From: David Innes
Sent: 14 September 2017 17:58
To: Planning.Responses
Subject: FW: Planning Application A/11/17/OUT

Closure of Brook Lane

Land South of A259 New Road and East of Brook Lane, Angmering, West Sussex – Planning Application A/11/17/OUT

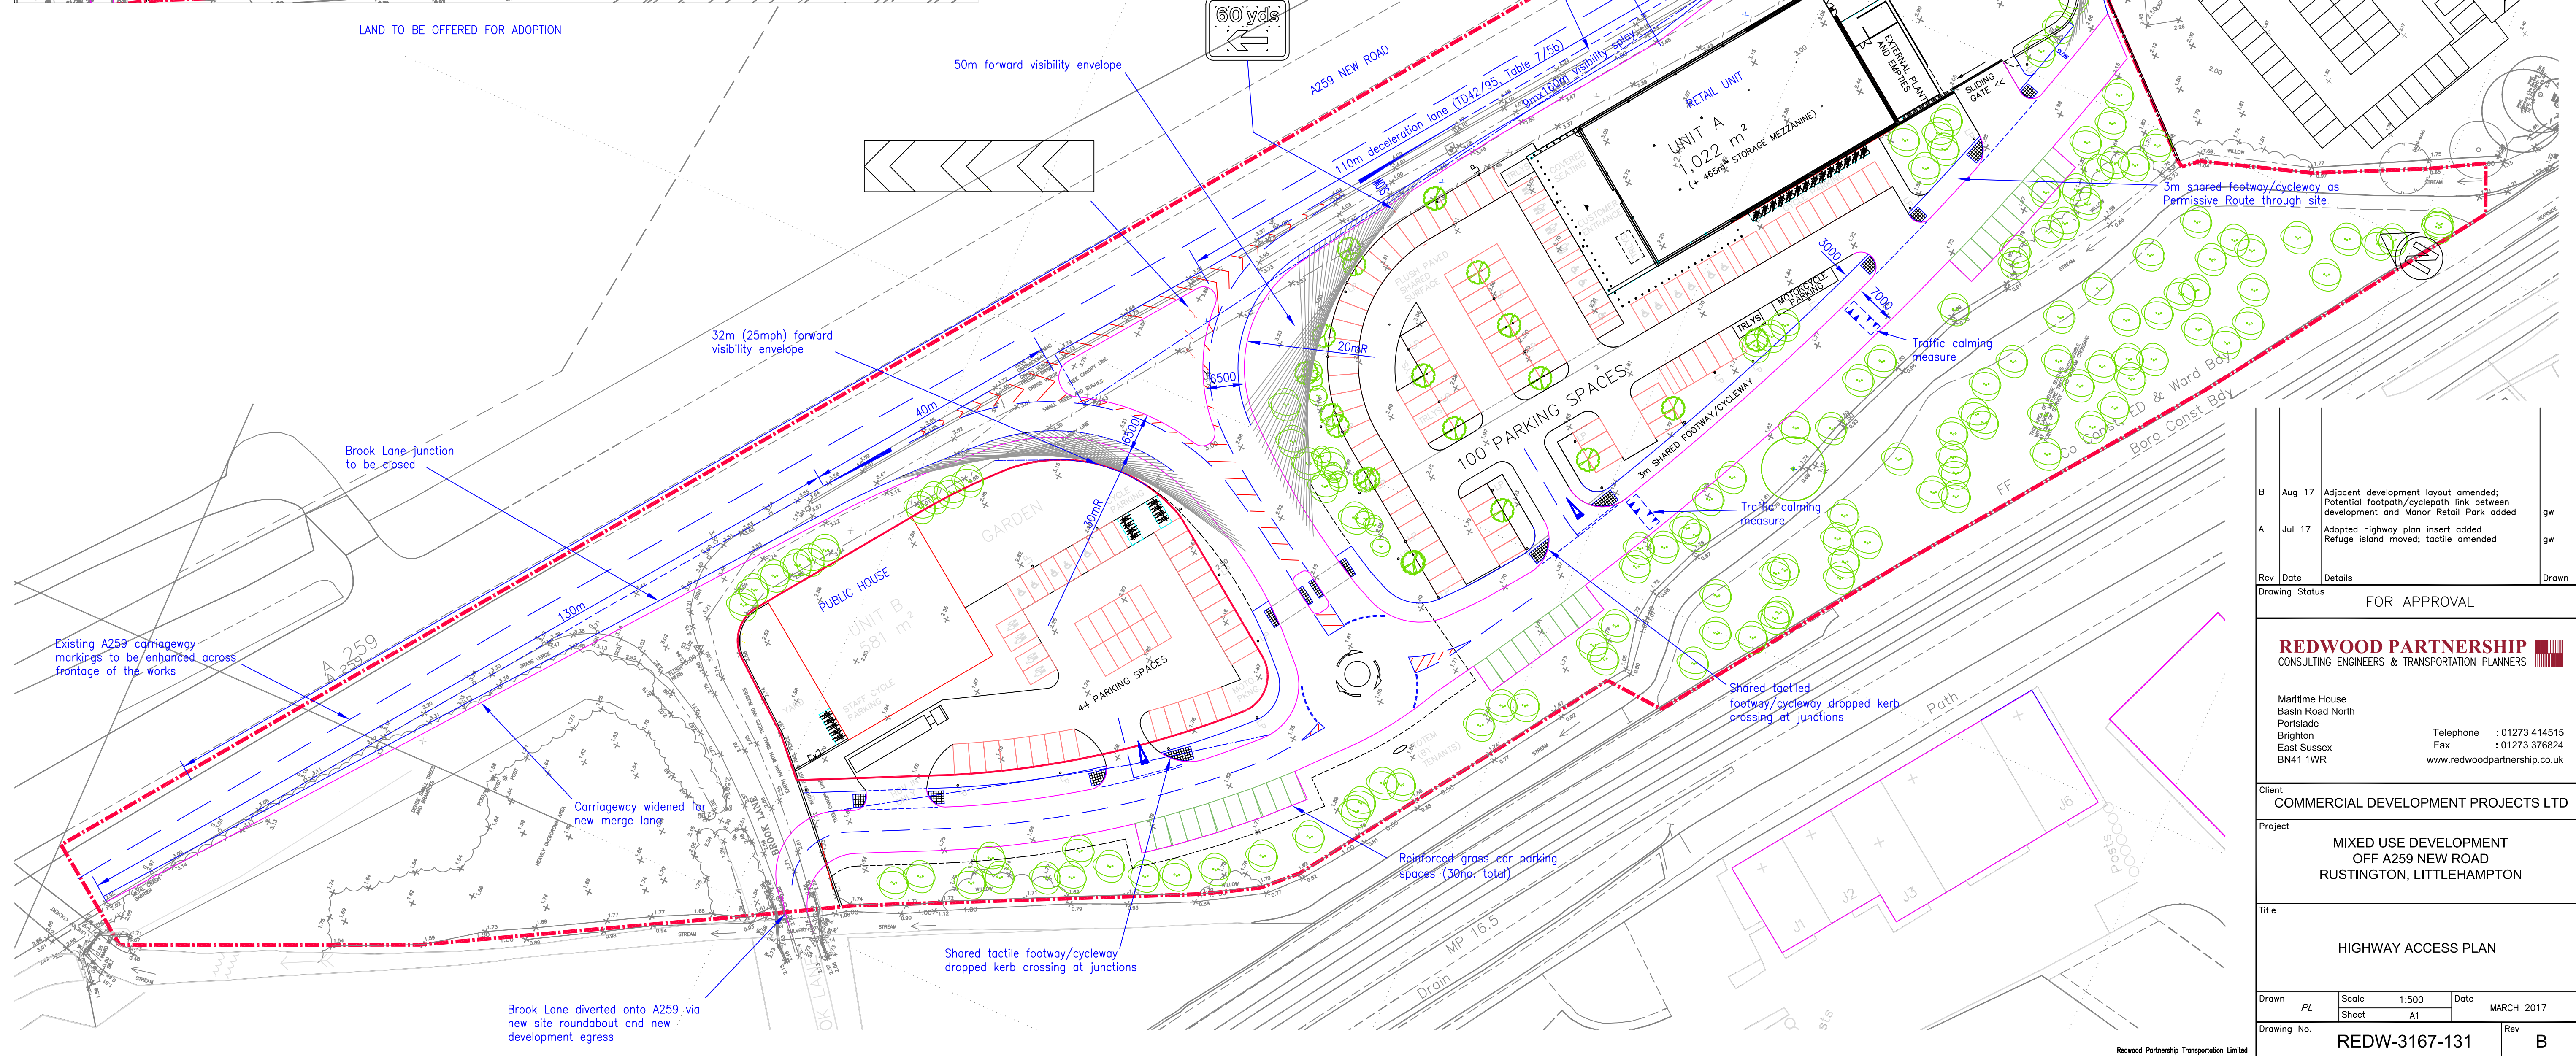
In respect of the access arrangements, these have been reviewed on the basis that Brook Lane is closed as shown on plan REDW-3167-131 Rev B. The condition suggested by the LHA requires that the access be implemented in accordance with the agreed plan. The LHA are of the view that the condition would require the closure of the road, given that this is shown on the plan. However, it is recognised that Brook Lane sits outside of the redline boundary, and therefore may not be sufficiently covered by the suggested condition should the need for enforcement occur. The LHA are satisfied to defer to the LPA's judgement as to whether the closure of Brook Lane should be specifically referred to in any condition attached should consent be granted.
